From: Holly Erdman
Sent: Wednesday, January 30, 2019 3:35 PM
To: Chelsea Benner
Cc: Jesse Cox
Subject: RE: Notice of Application CB-19-00001

Please review the following Boundary Line Parcel Combination application submitted by Peter Ackroyd (CB-19-00001). Any comments need to be submitted by 5pm on February 14th. Please let me know if you have any questions.

LOCATION OF EXISTING
STRUCTURE

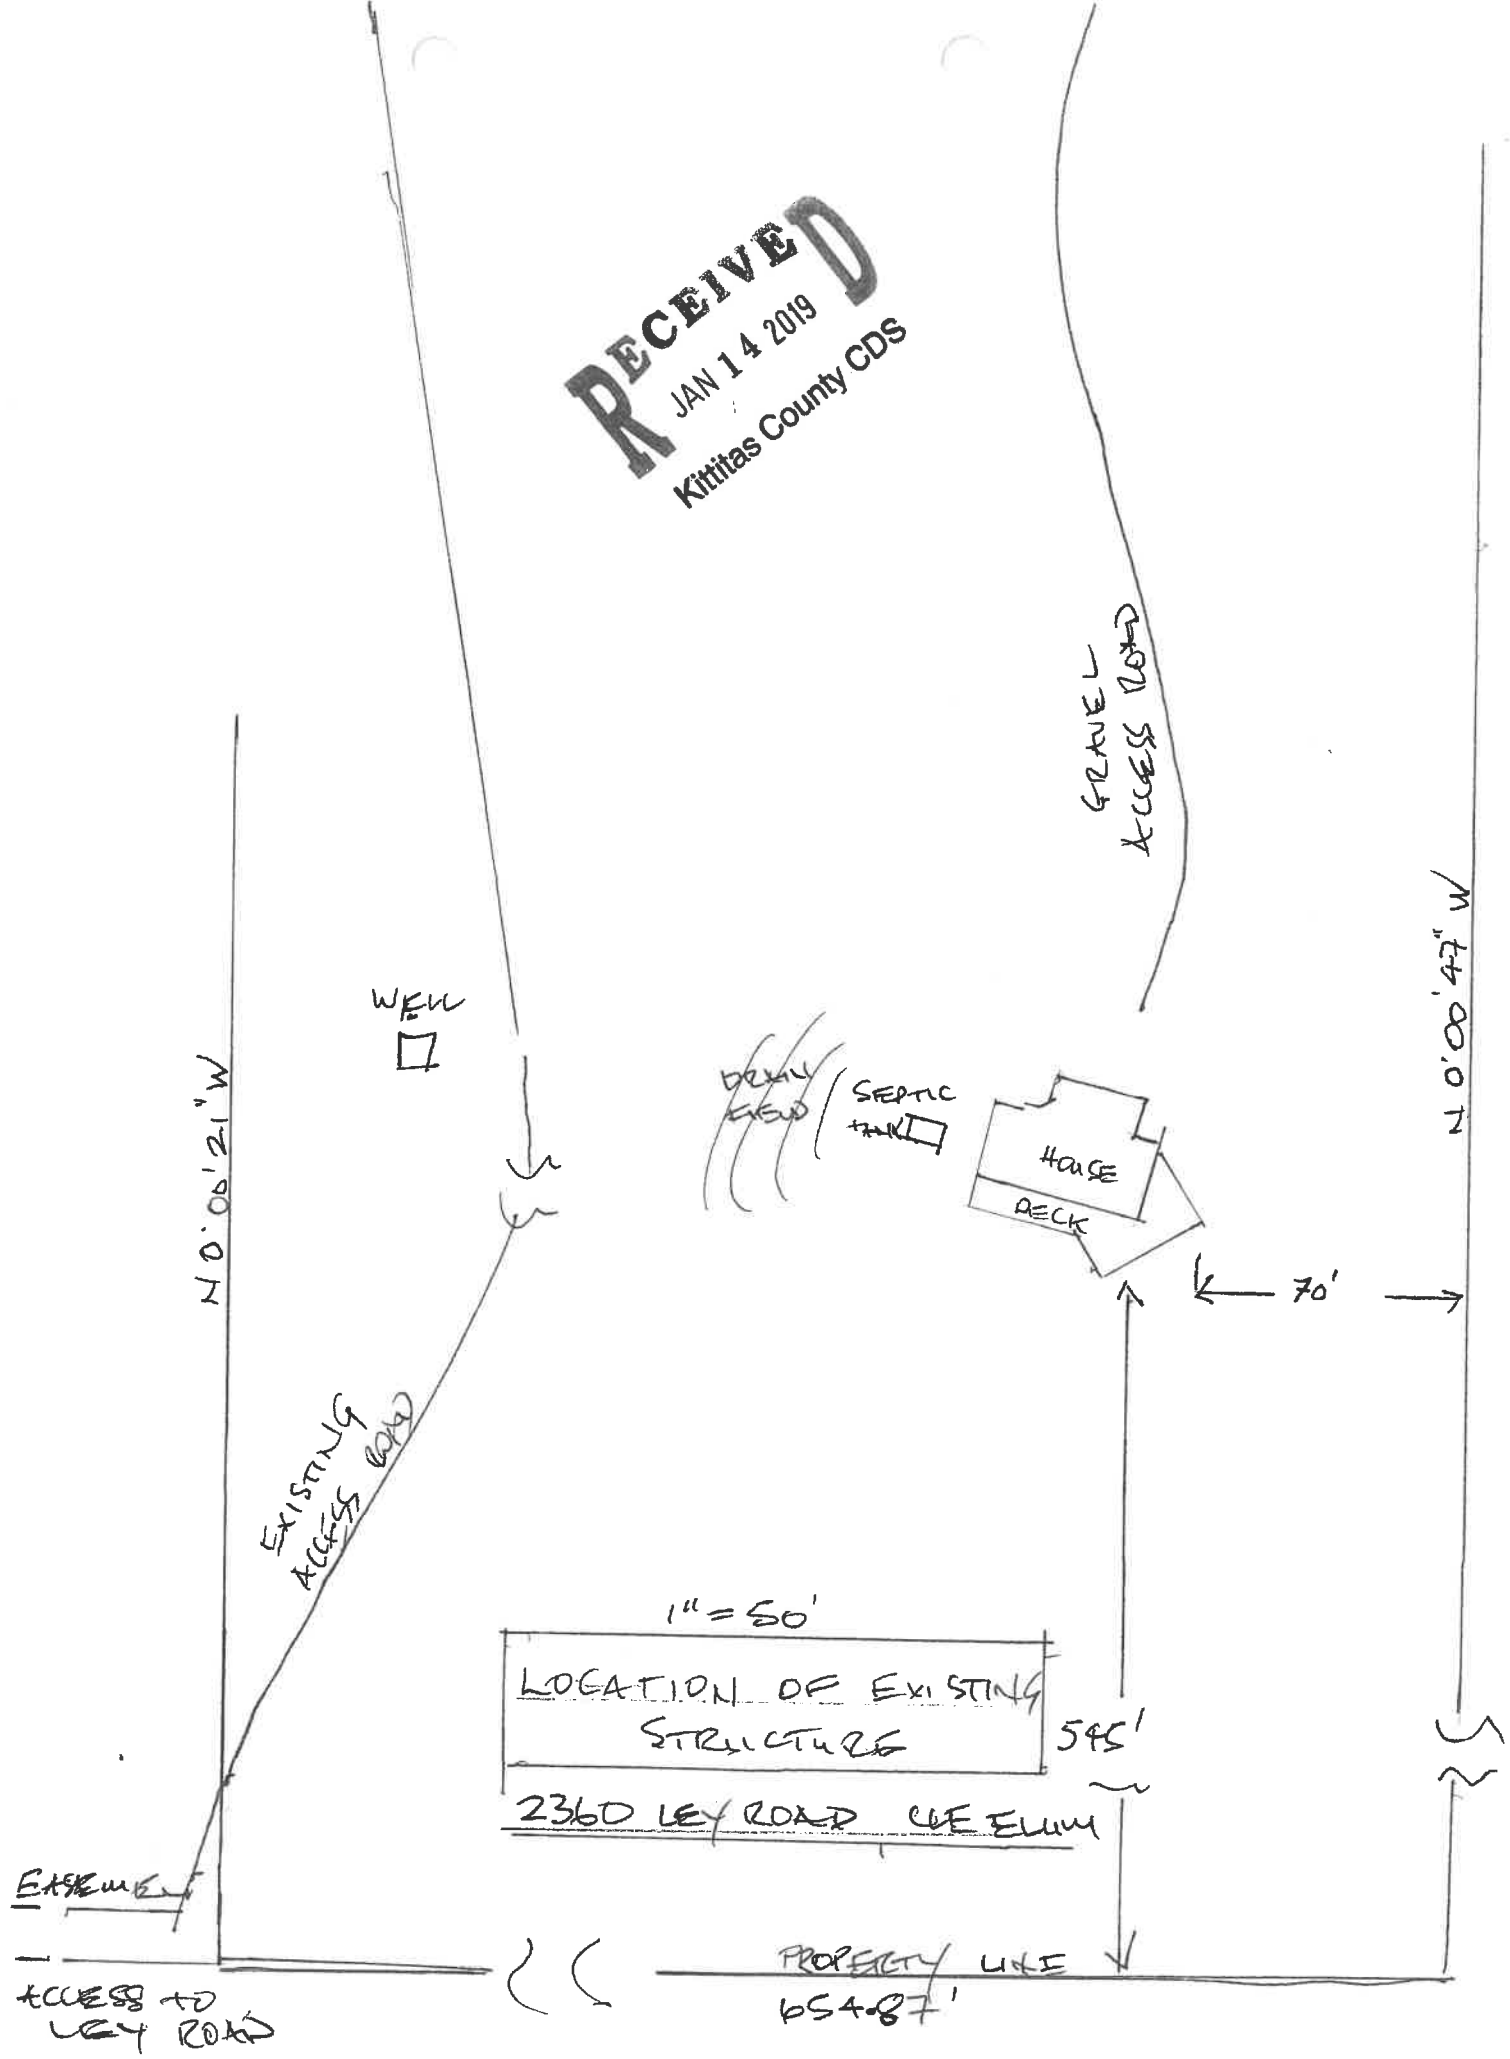
Thank you for this opportunity to comment. On the site plan provided, the distance from the property line to the well is unclear. A scale is provided but following that scale, the well doesn't meet the required 50 foot property line setback. Public health needs to know the distance the well is from the proposed property line.
